DRB Application No.: 03-00014 (SBP)	Project # 1002410
Project Name: CRYER PROPERTIES	EPC Application No: Z-97-121, Z-97-129
Agent: Sterling Capital Development	Phone No.: 933-0725

9. Project # 1002410
03DRB-00014 Major-SiteDev Plan BldPermit

DEVELOPMENT REVIEW BOARD
January 29, 2003
Project # 1002410

Project # 1002410
03DRB-00014 Major-SiteDev Plan BldPermit

OVERALL SITE PLAN

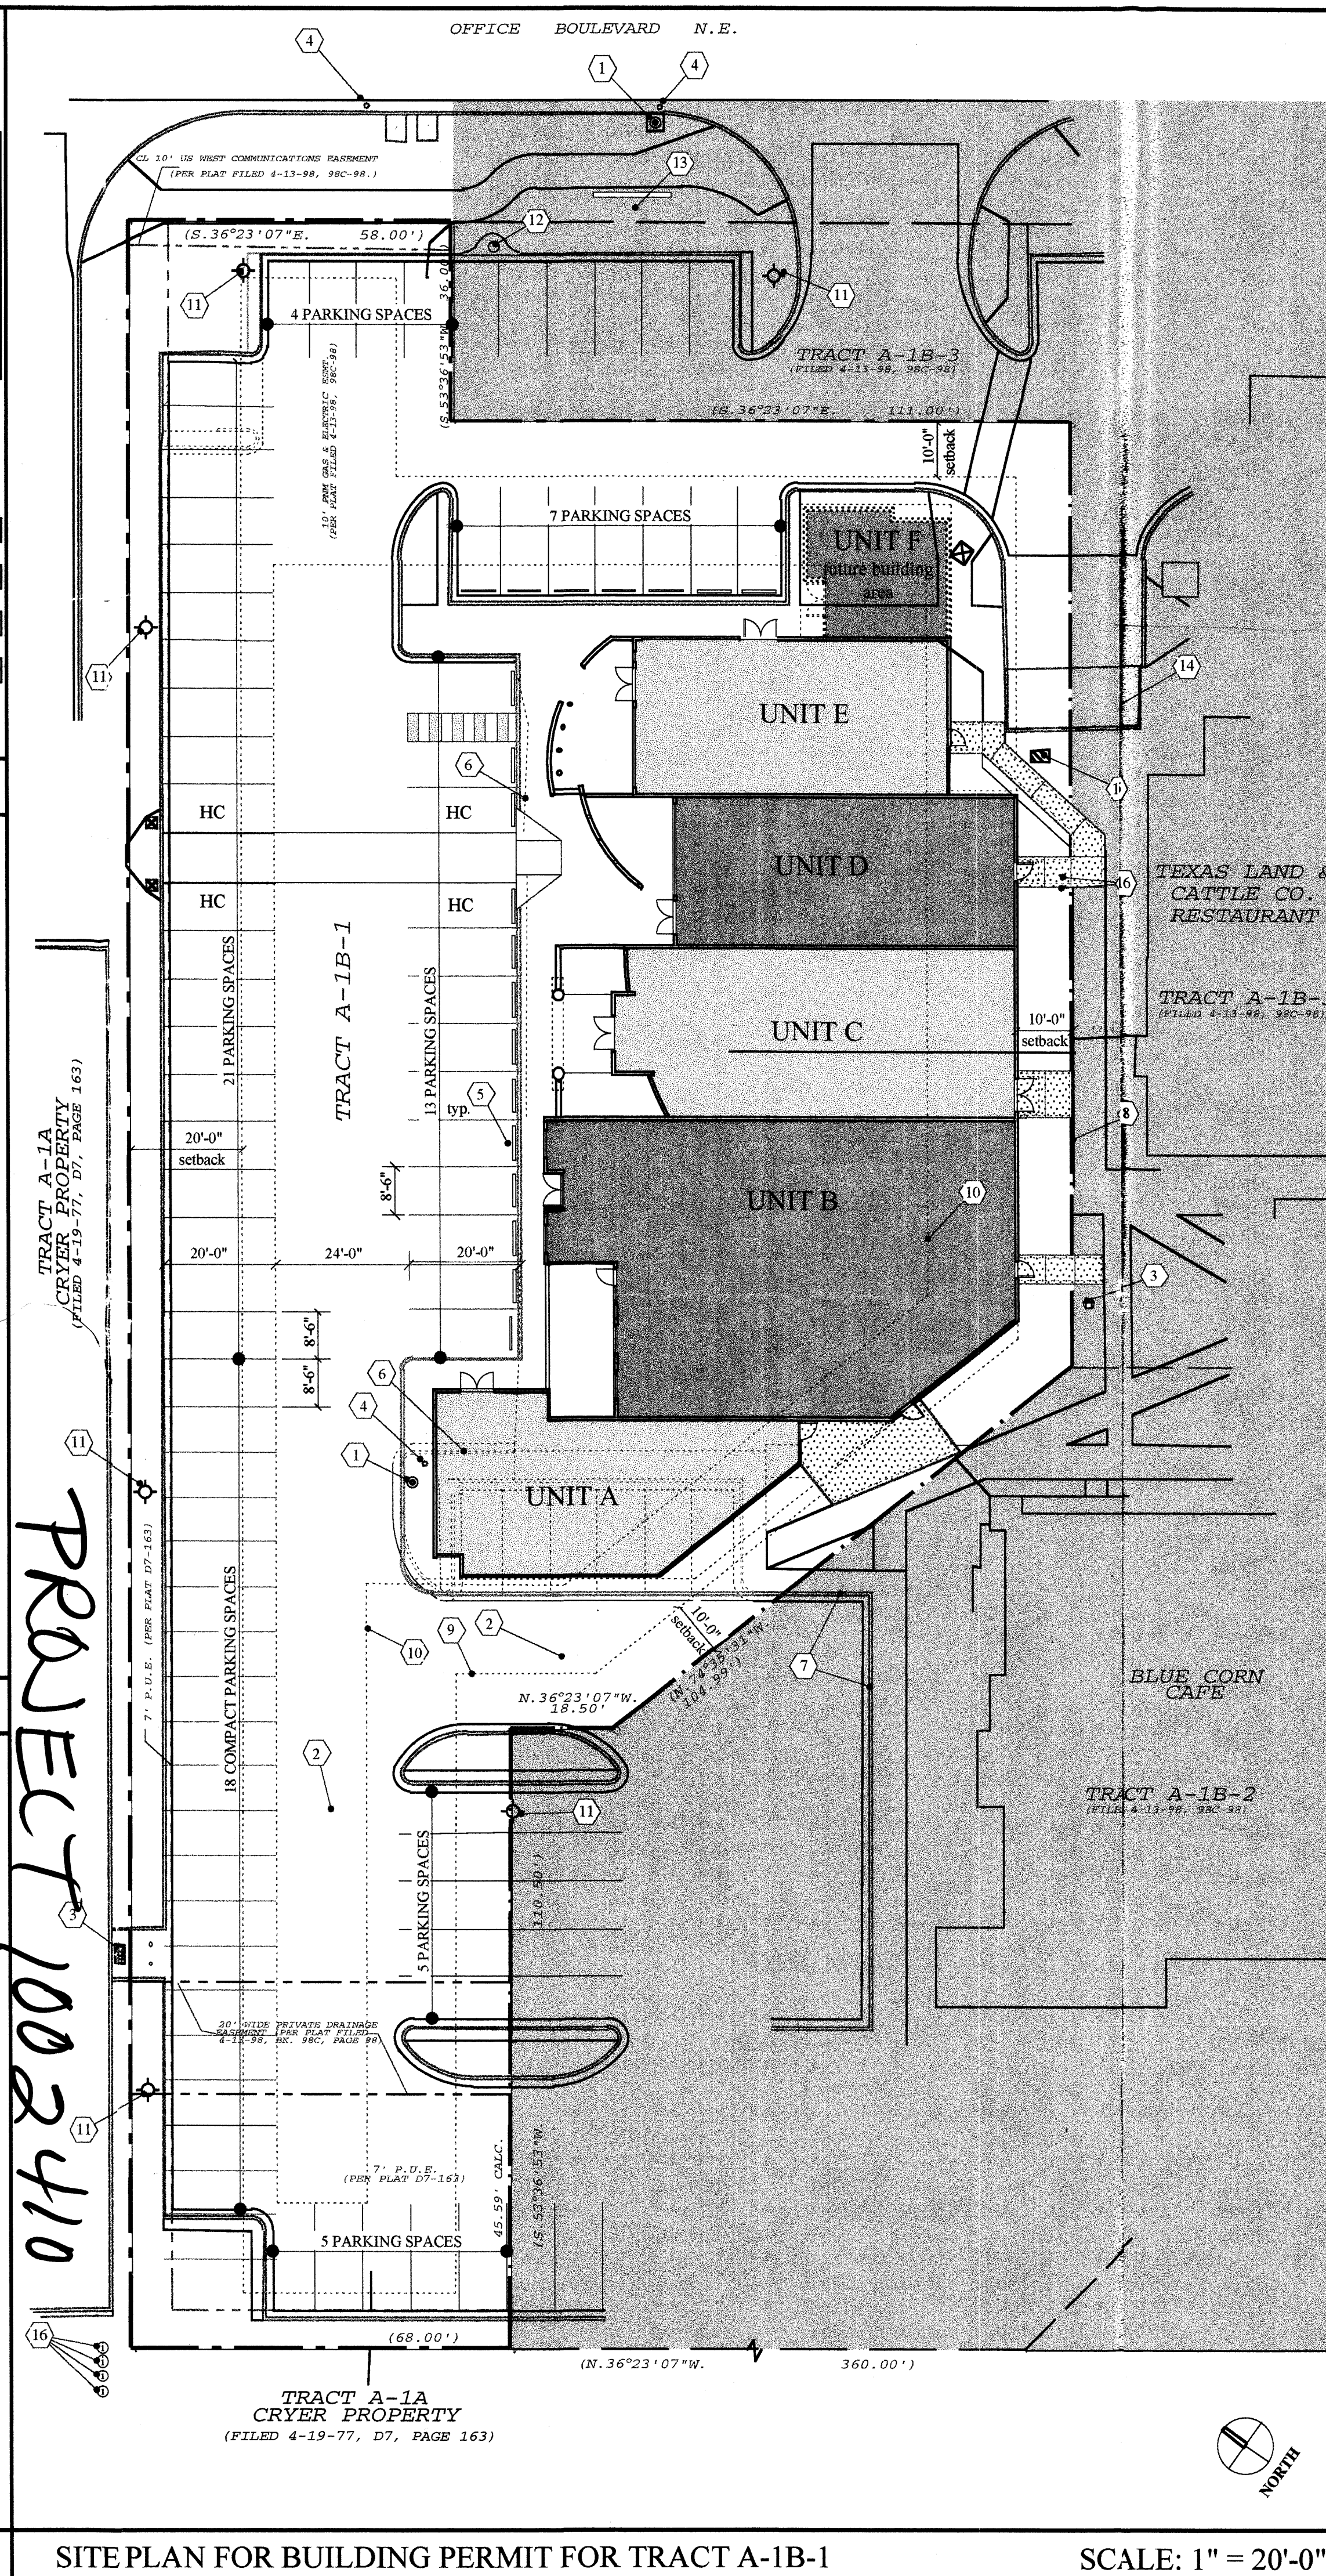
Fire hydrant requirements can not be figured without construction type. All required Fire Hydrants must be shown on site plan for approval.

How are cross access easements addressed? Where are the pedestrian routes for the site as a whole? This development needs to conform to the TIS as applicable.

The sheet which is labeled "Partial Site Plan" should be re-labeled to read "Site Plan for Building Permit for Tract A-1B-1" to clearly distinguish it from the already approved Site Plan for Subdivision which included all 3 tracts & was approved by EPC in 1997.
